Your Ref: OWPC21758
Our Ref: Y/8/19/HH 04-02-2019
Please ask for:
Amber Willard

Single storey side extension linking semi-detached garage to existing house including conversion of existing garage to habitable use and rear extension. This application affects the setting of a listed building.

Hazel Cottage Church Lane Yapton

PROJECT TITLE Proposed Development at Hazel Cottage Church Lane Yapton Arundel	DRAWING TITLE Proposed Elevations		No	REVISION	DATE
	STATUS Planning Application				
	SCALE 1:100 @ A3	DATE 03.01.2019			
	DRAWN BY DE	DRAWING NO PA-302-06

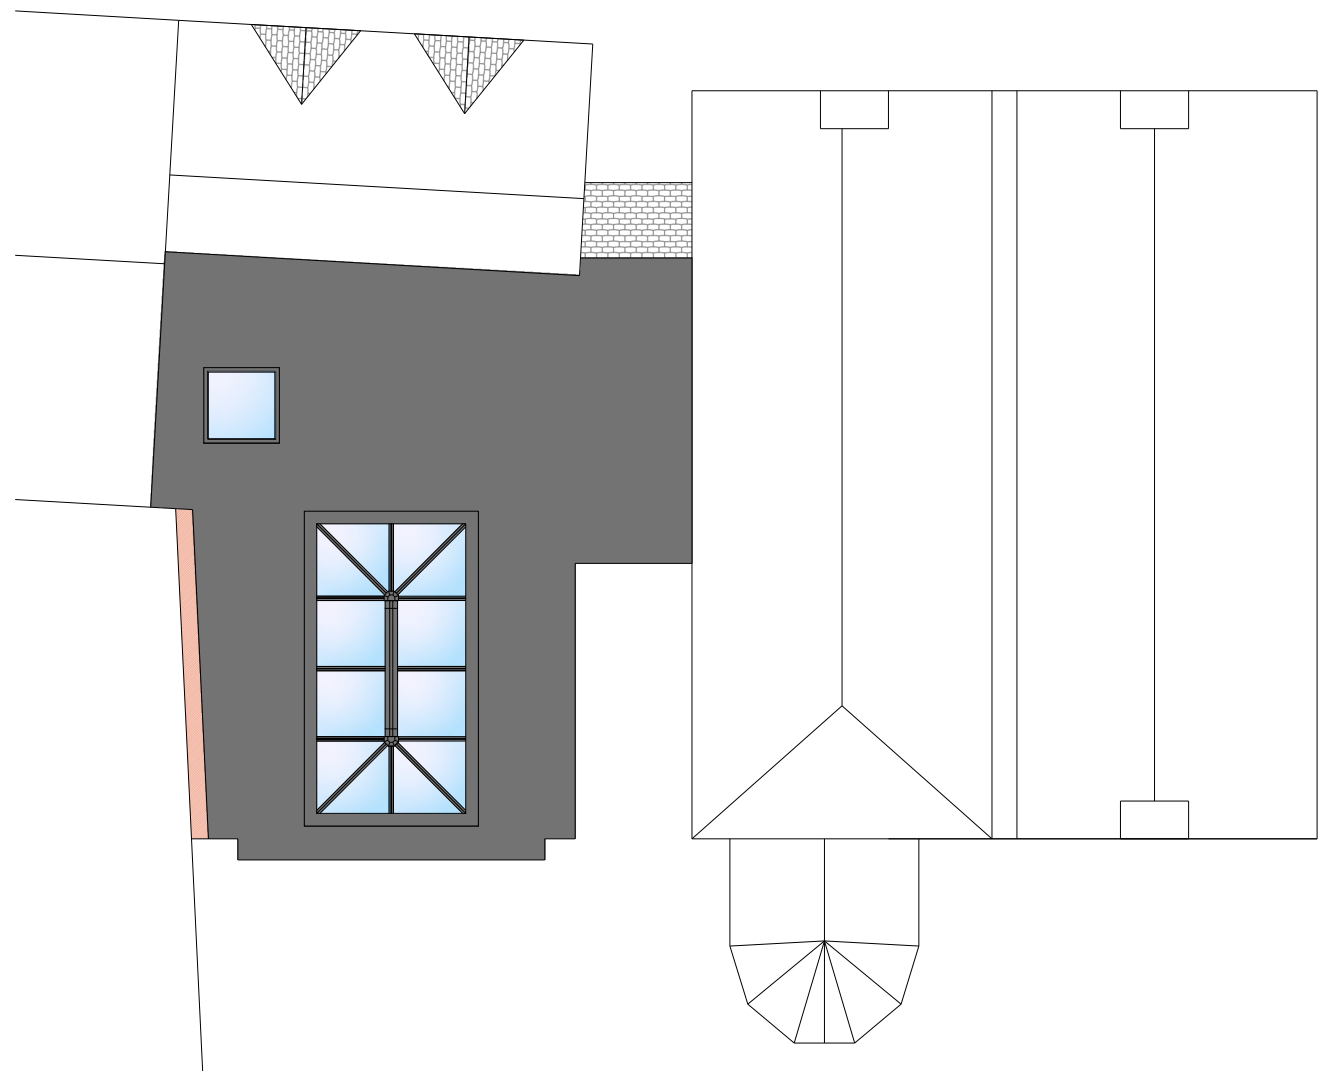
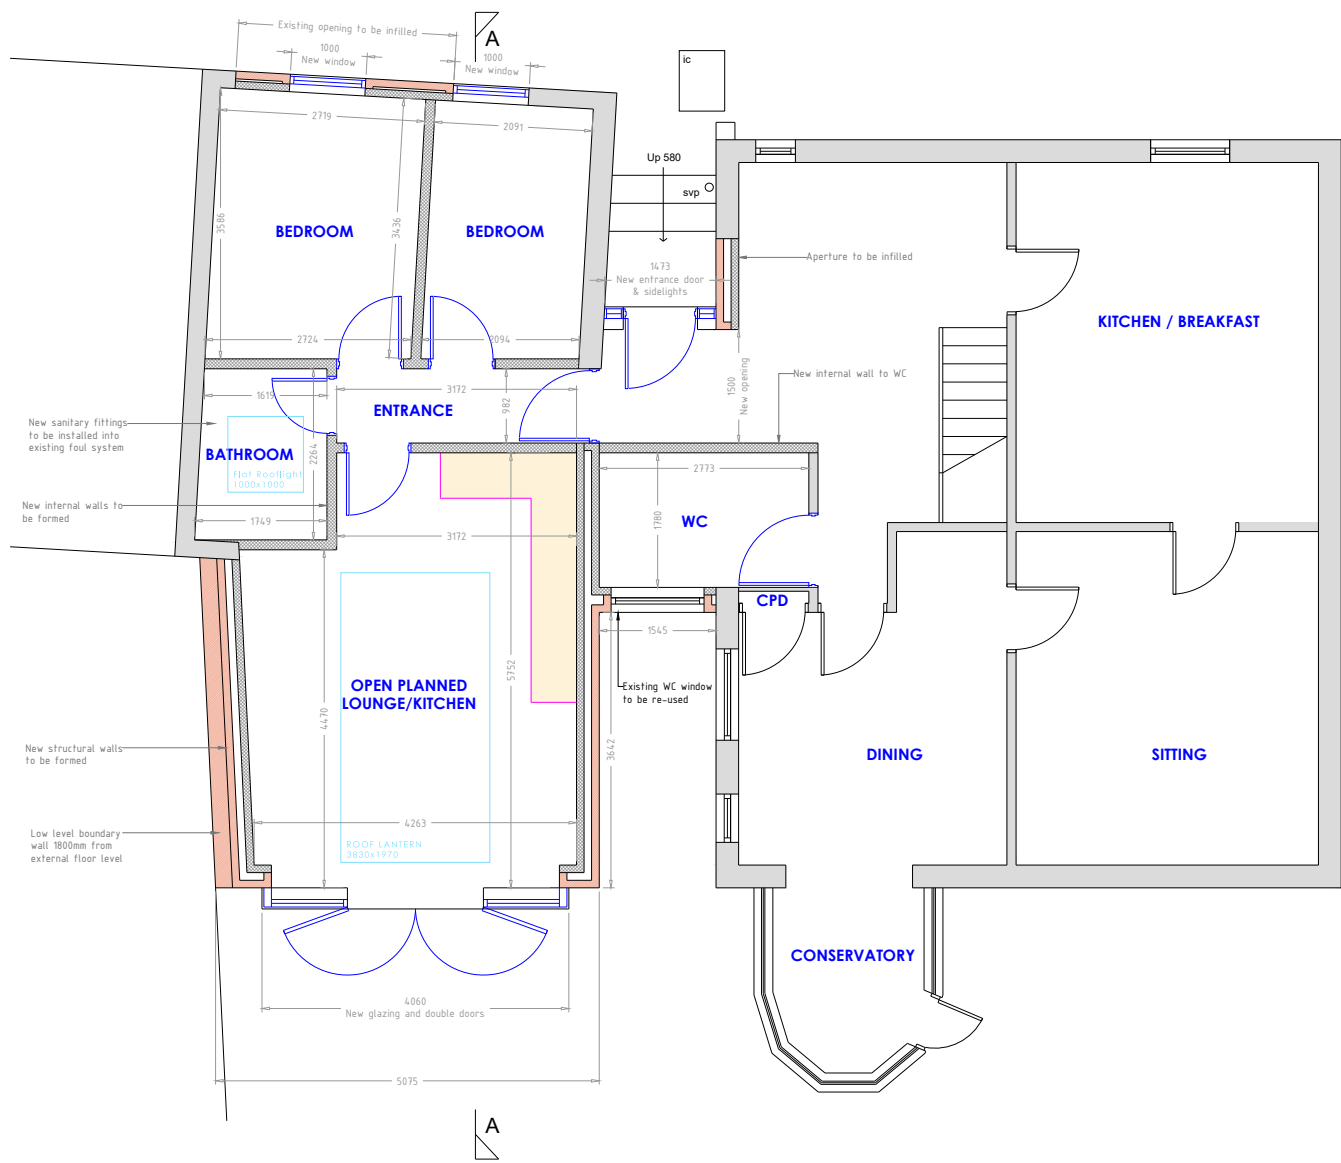
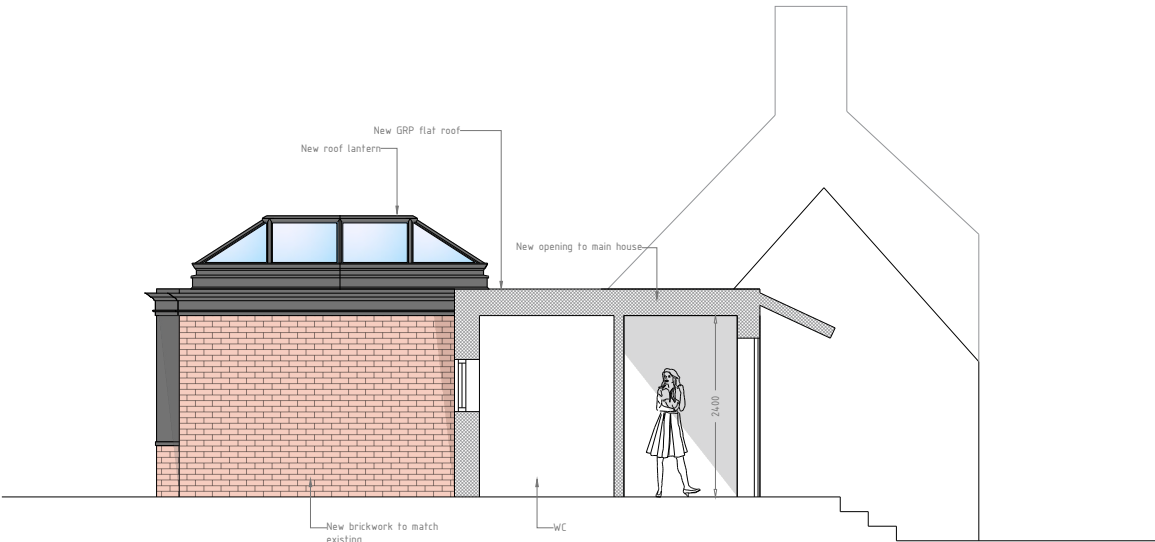
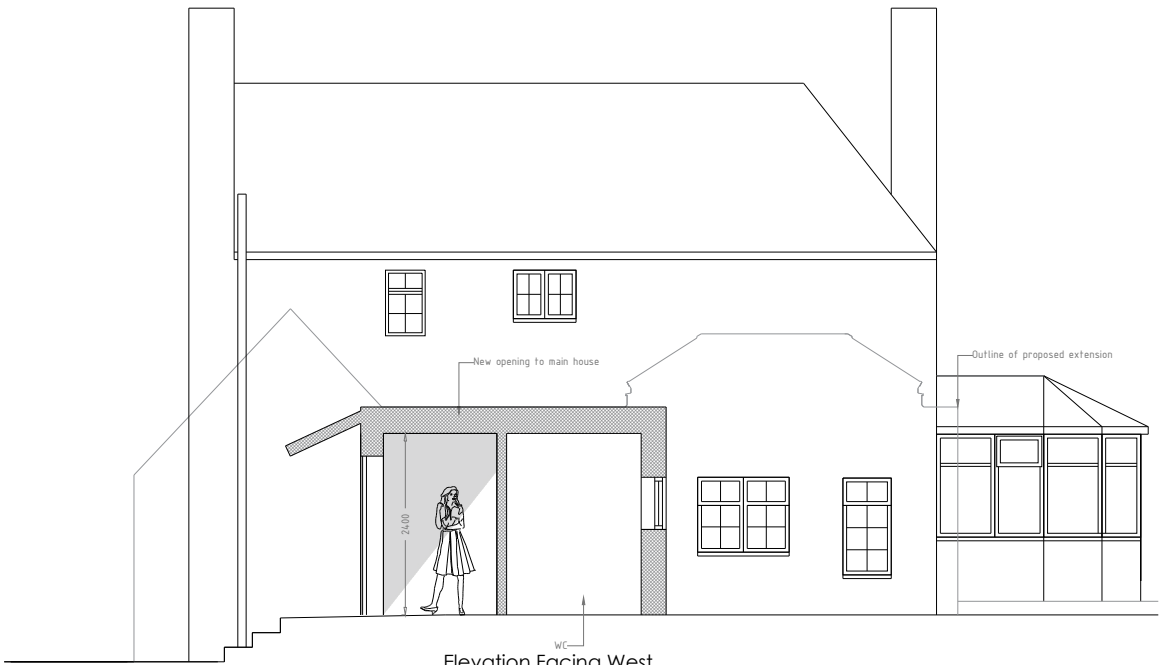
If the garage was restructured to the proposed design it would be completely out of character with the neighbouring building and form a 'terrace' instead of two separate dwellings. Surely it is not appropriate to demolish part of a listed building and connect another structure to it? This application should be refused.
